ENG-SP20008-R2-GEC-redlines Markup Summary

Subject: SW - Comment
Page Index: 2
Date: 4/5/2021 11:54:21 AM
Author: GReese
Color: ■
Layer:
Space:
Page Label: [2] 2 GR_01 - GR01

SHEET 3 OF 10
JOB NO. 25188.00

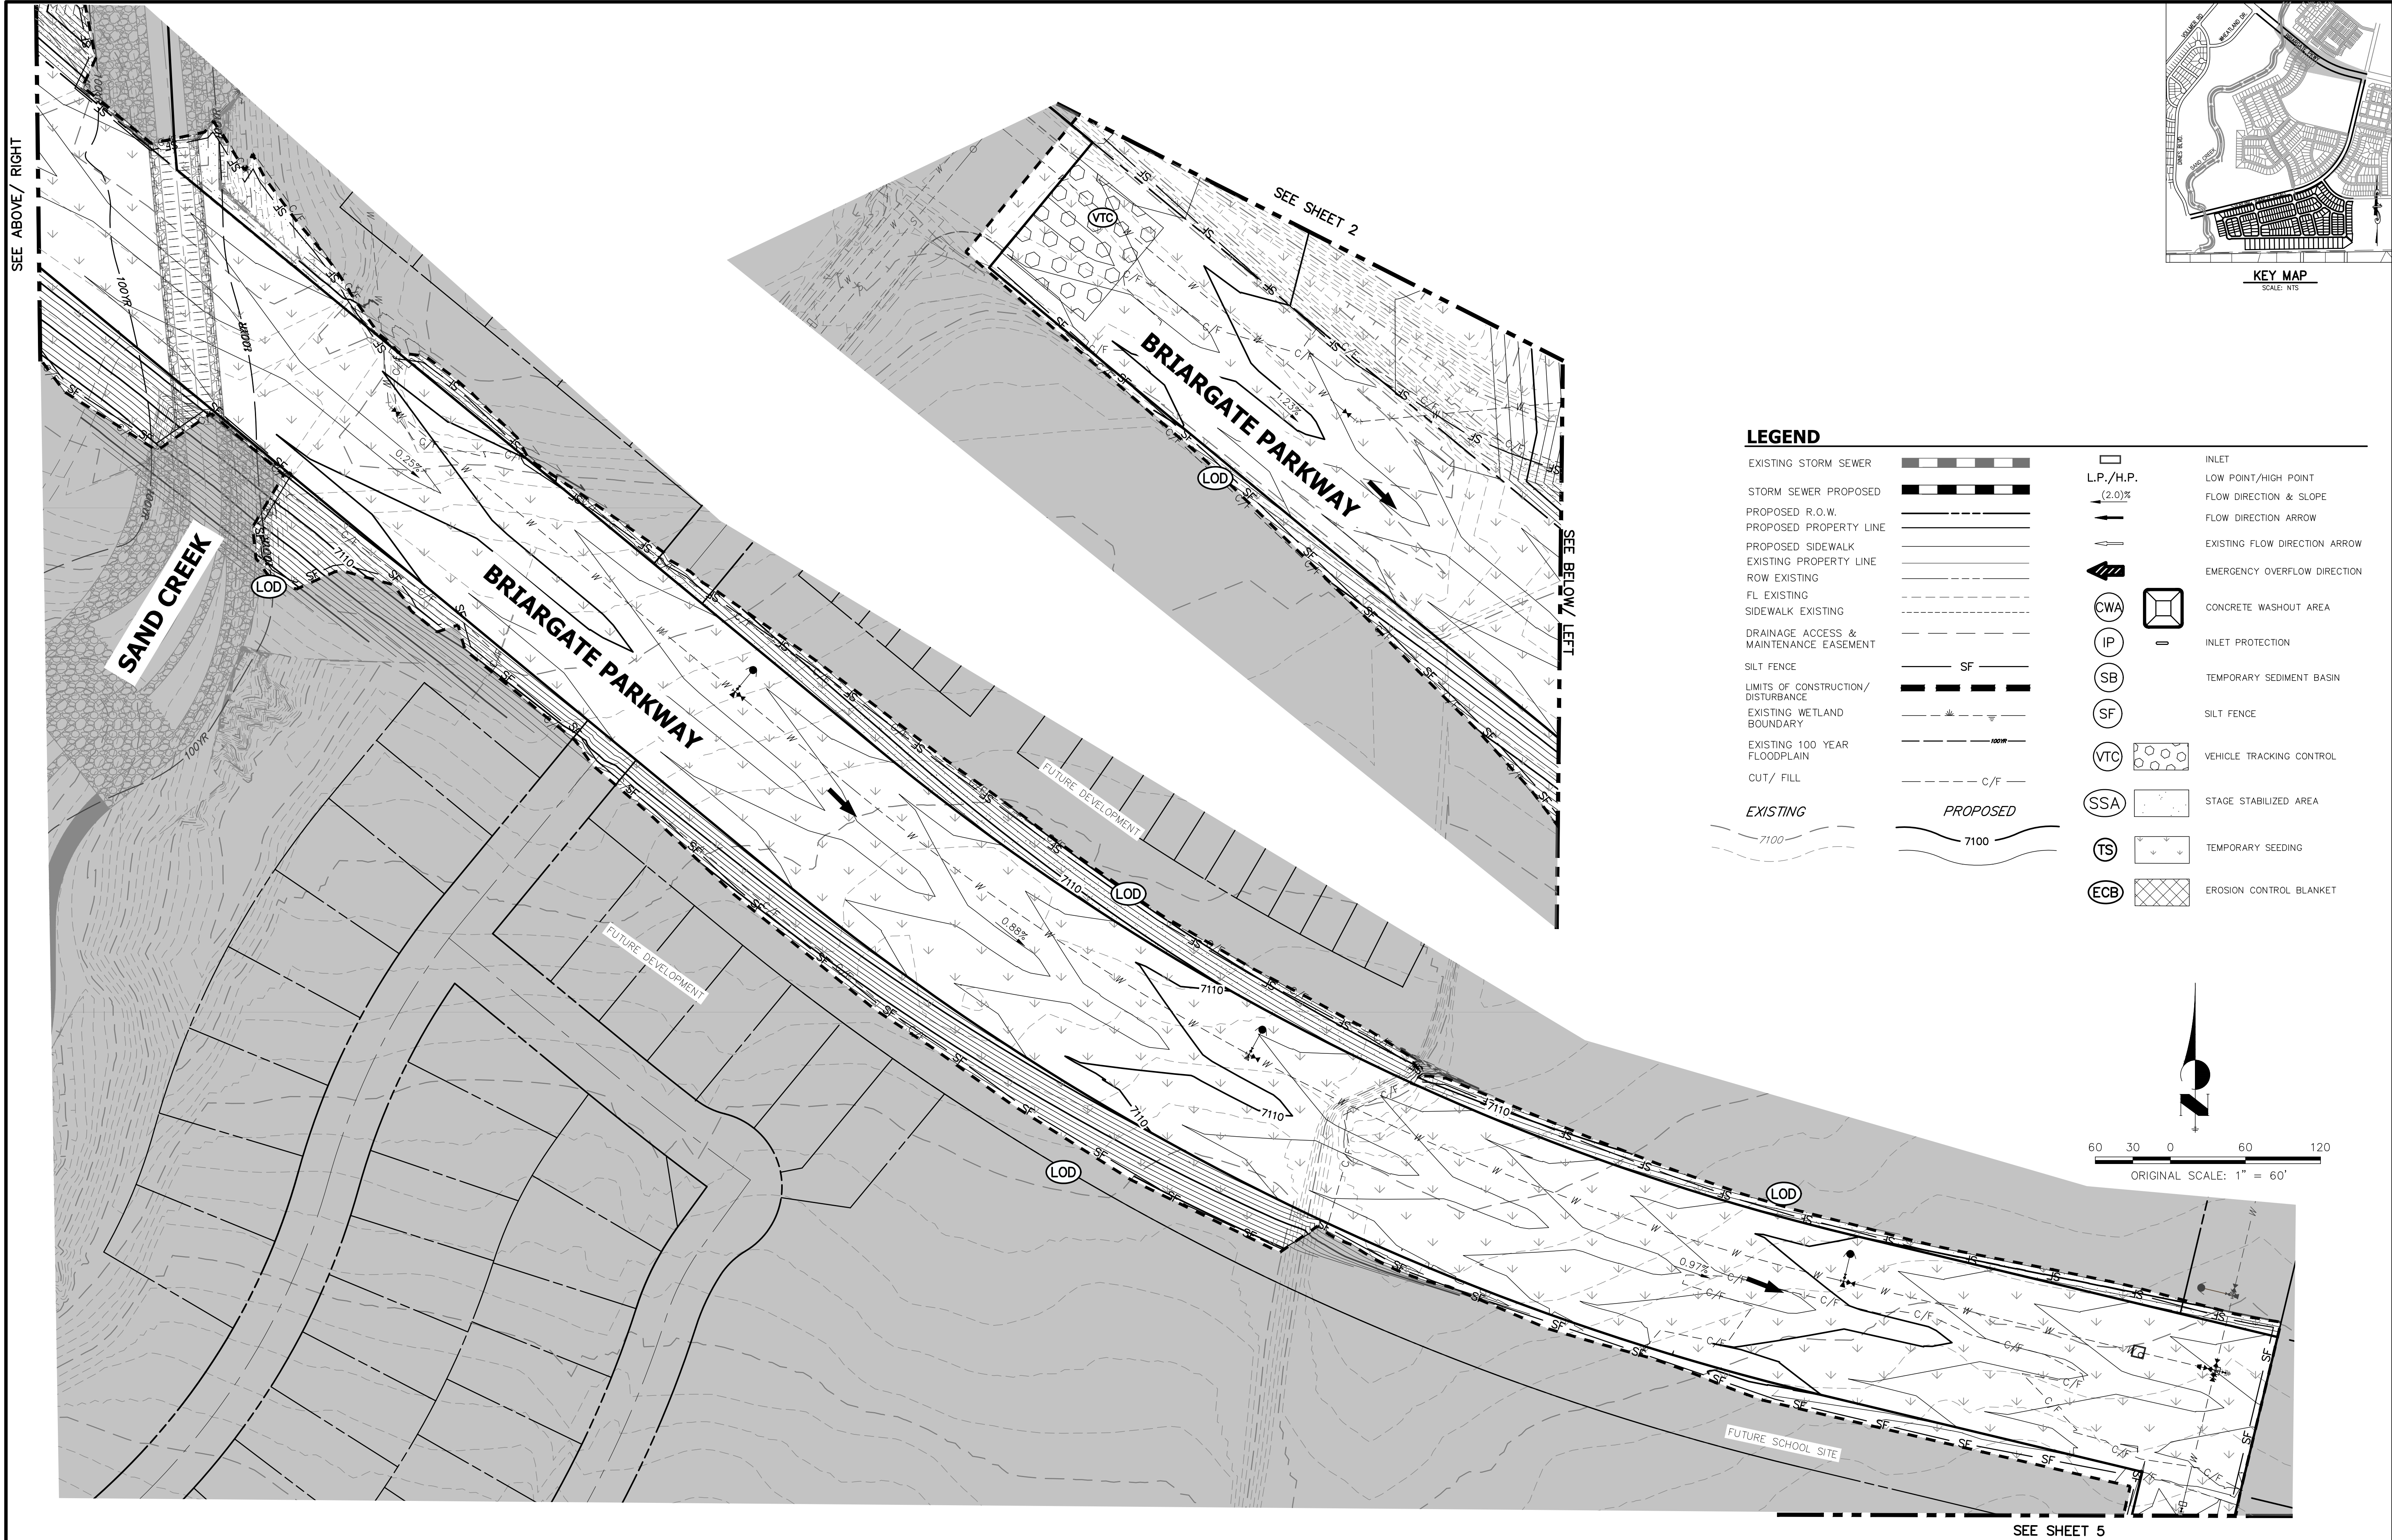
Show check dams (rock socks, straw bales, etc) in rough cut street drainage (typical all sheets). And add detail of selected BMP to last sheet. Also see MHFD Detail EC-9 and add that to last sheet.

JR Response:
Addressed.
